PRELIMINARY/FINAL DRAINAGE REPORT FOR PINE VIEW ESTATES

JUNE 2020

SP-20-004

SF-20-019

# PINE VIEW ESTATES FILING NO. 1 PRELIMINARY PLAN

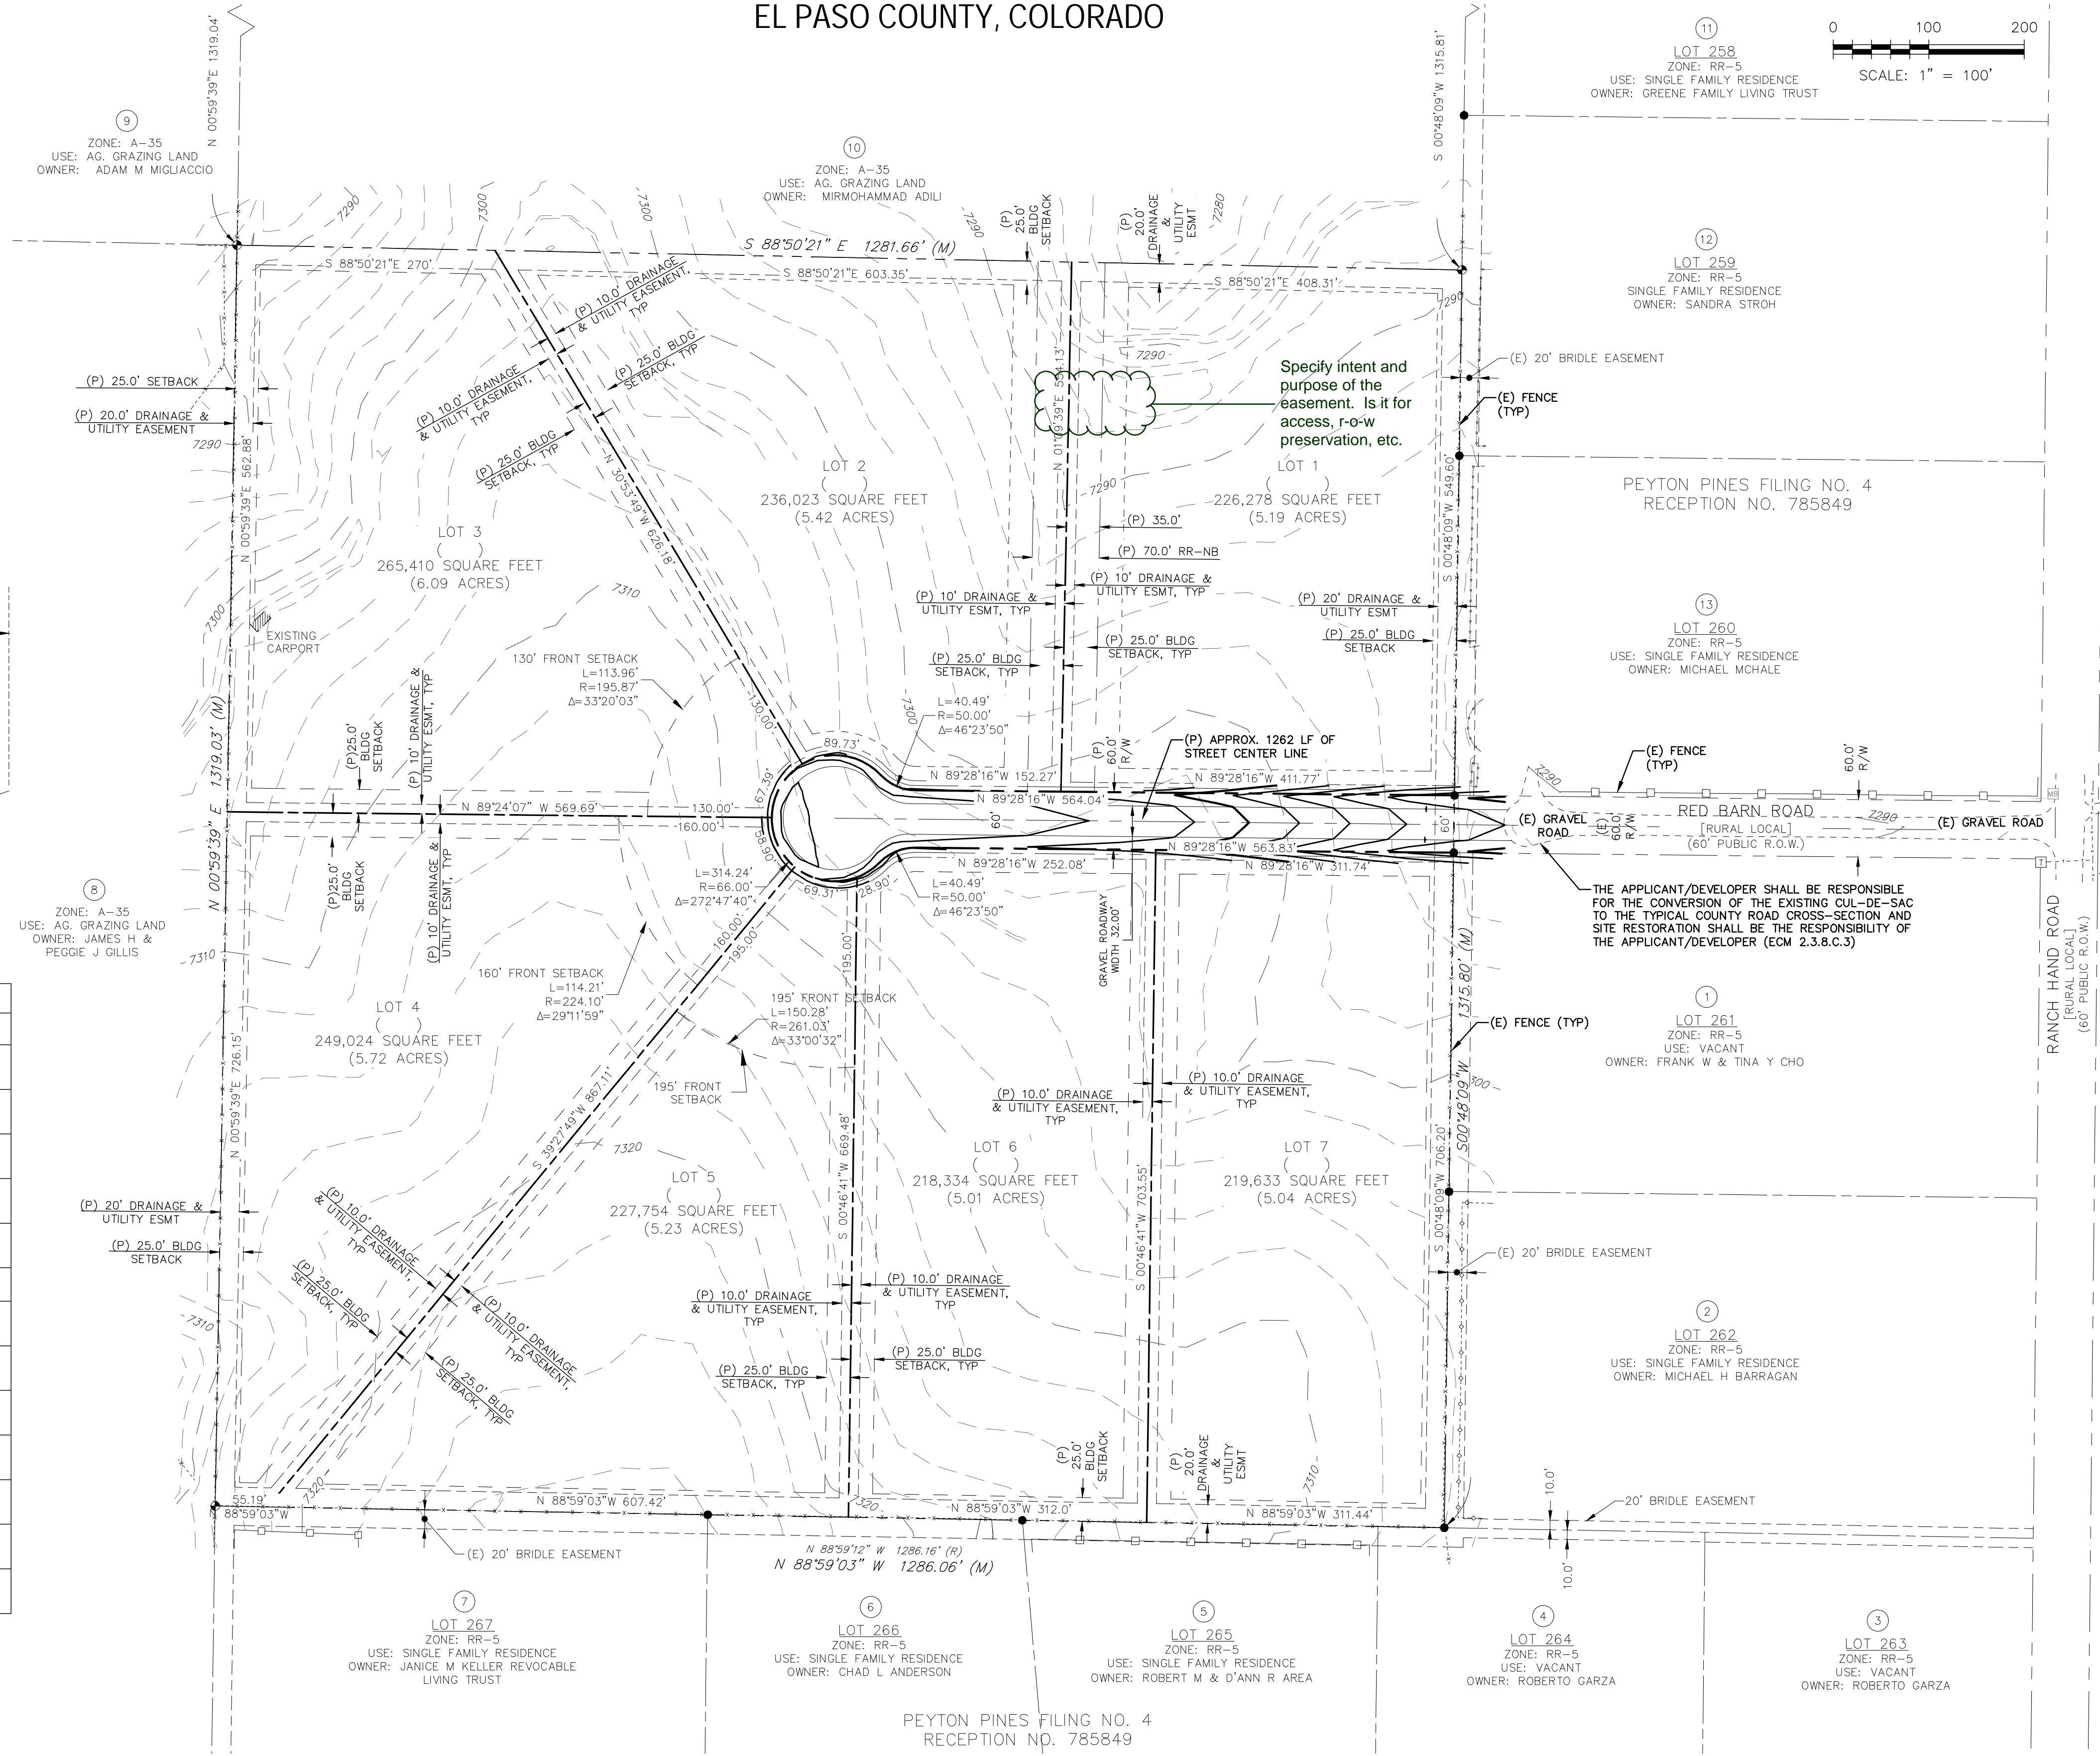
See comment on Prelim Plan
Drawing in regards to the need
for a permanent WQ facility
